From: Simon Davis
Sent: 30 April 2019 10:47
To: Angus Eitel [REDACTED]
Subject: BN/12/19/PL The Cottage Piggeries - Changes to Replacement Dwelling.

Proposed Roof Plan

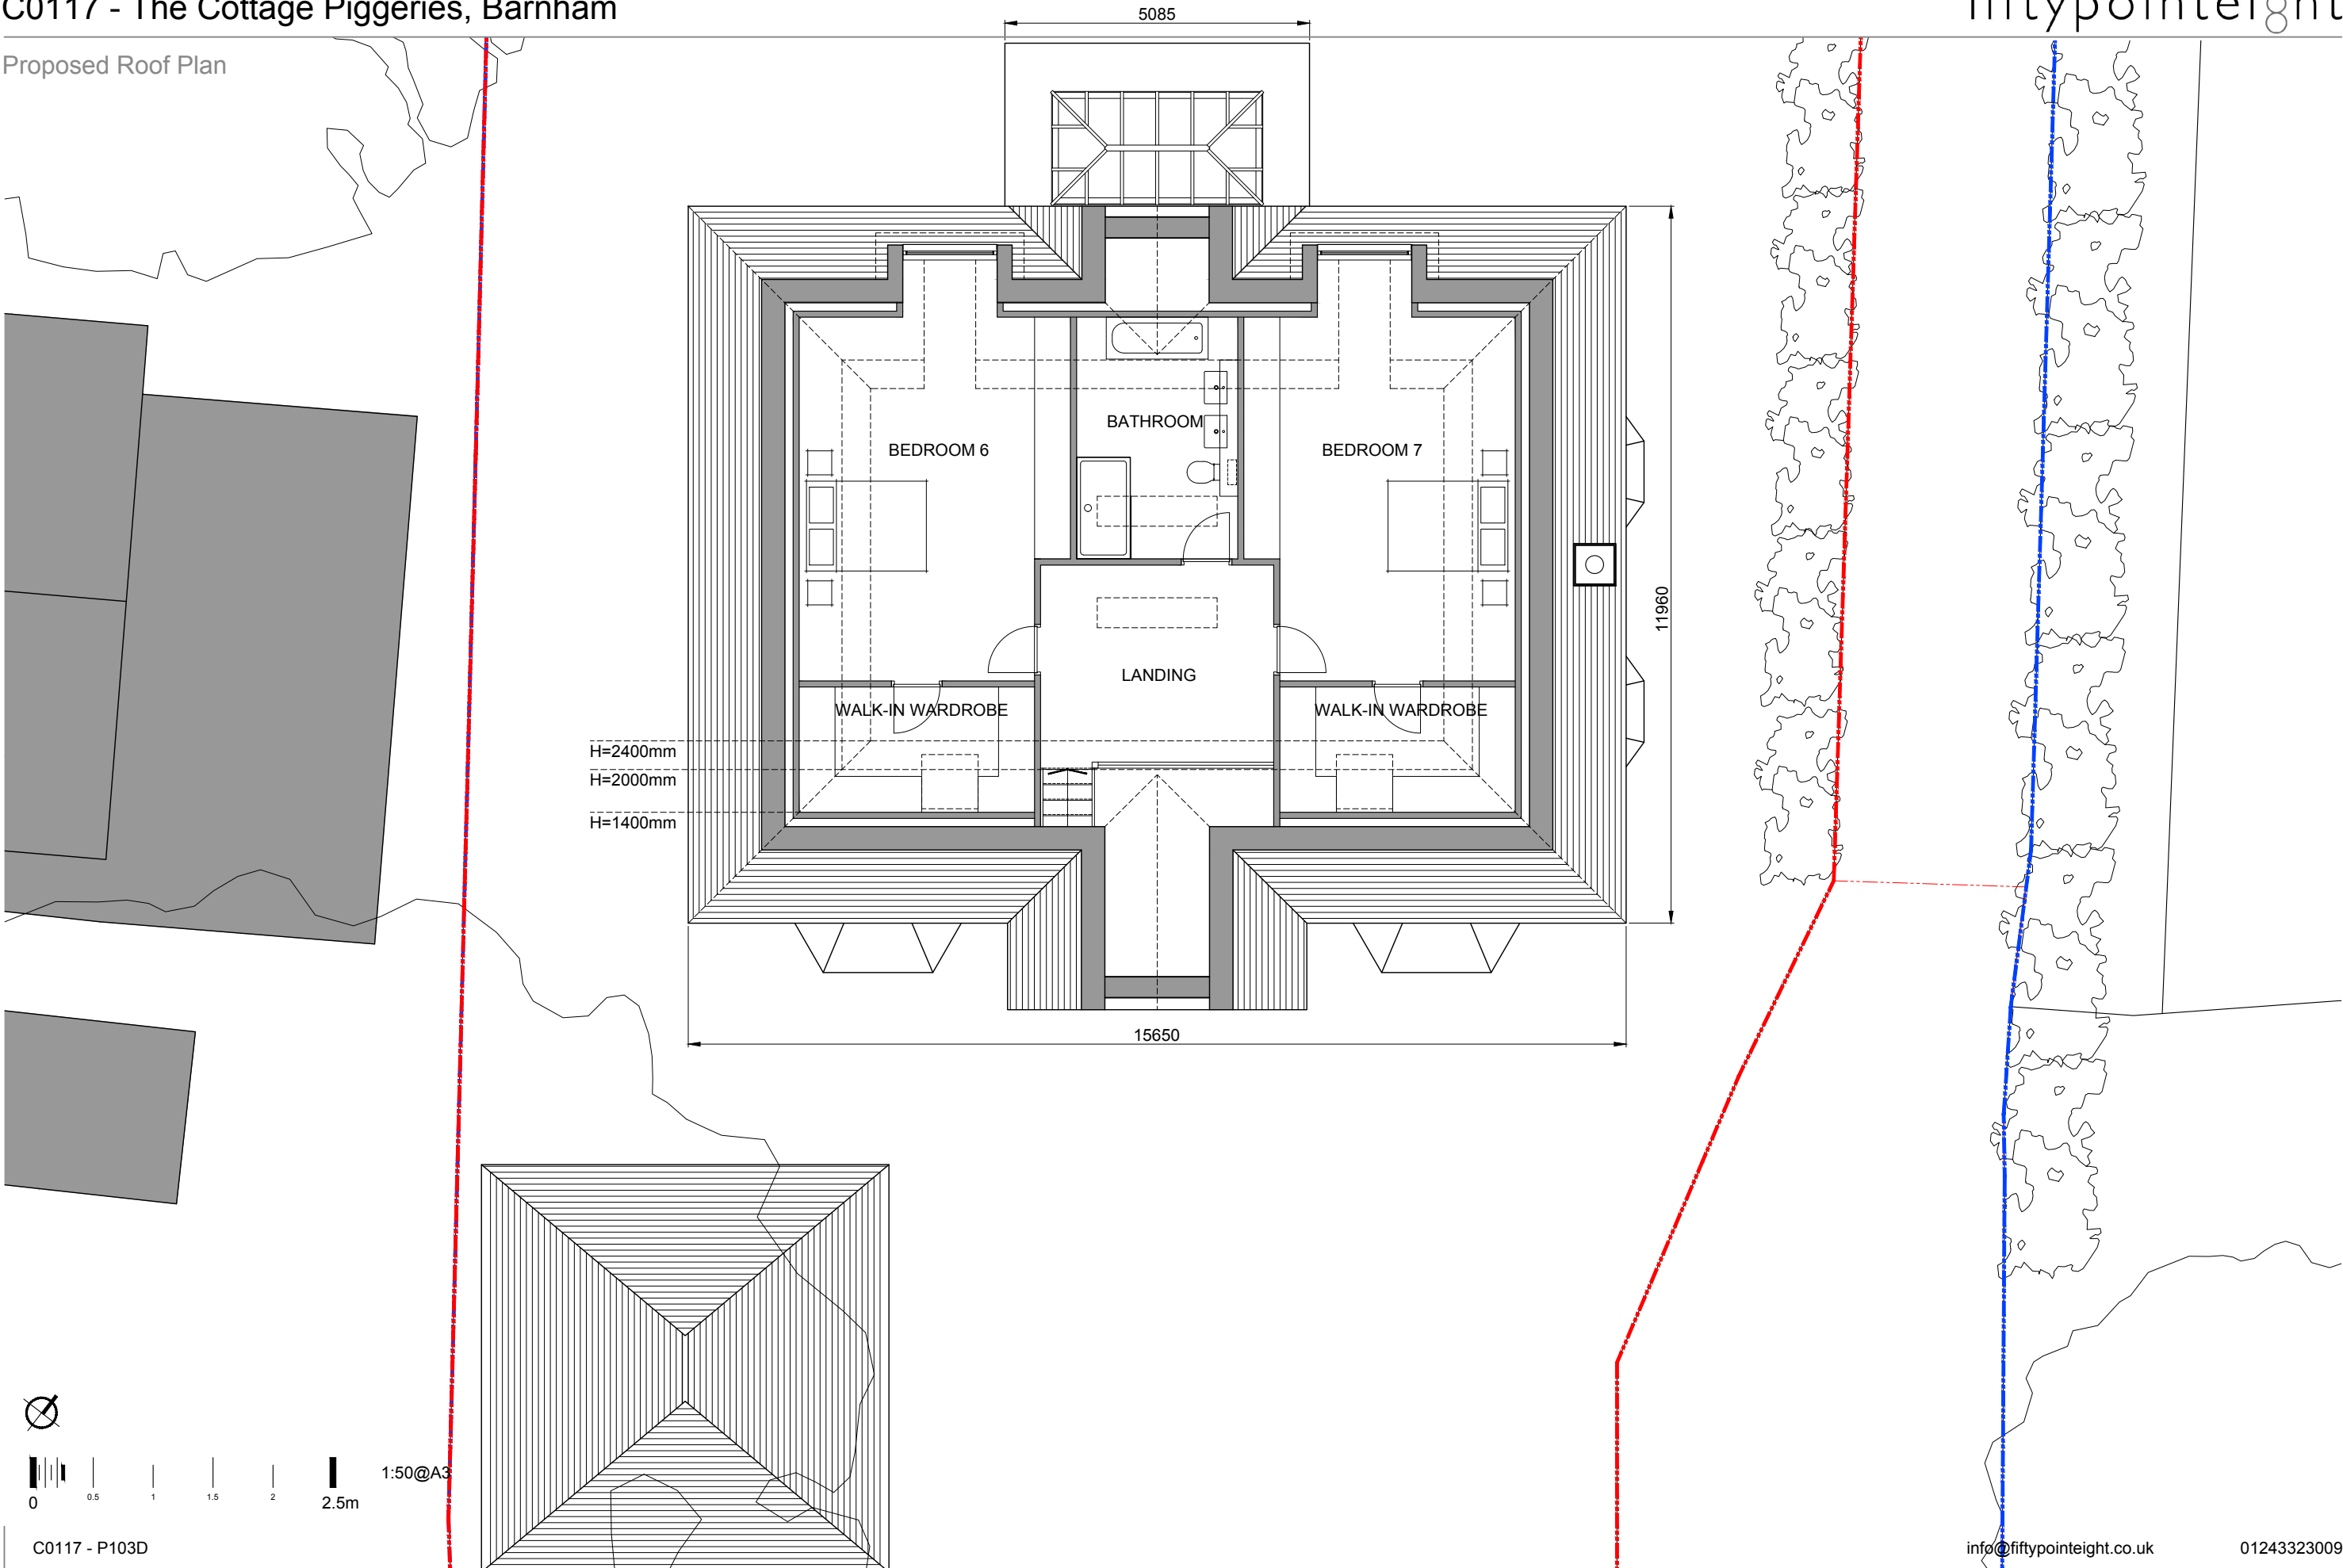
I have spoken with Albert this morning and I said that I would have a think about how we are likely to recommend BN/12/19/PL for the additional accommodation in the roof. I have duly looked at the plans and consider it likely that we will recommend approval. At the present time this will be a delegated decision but this could change if we get a response from the Parish Council. Can you provide me with a cross section of the proposed roof level accommodation so that I can check the heights of the velux windows. Subject to this, we may or may not need to impose an obscure glazing condition on these two velux windows.
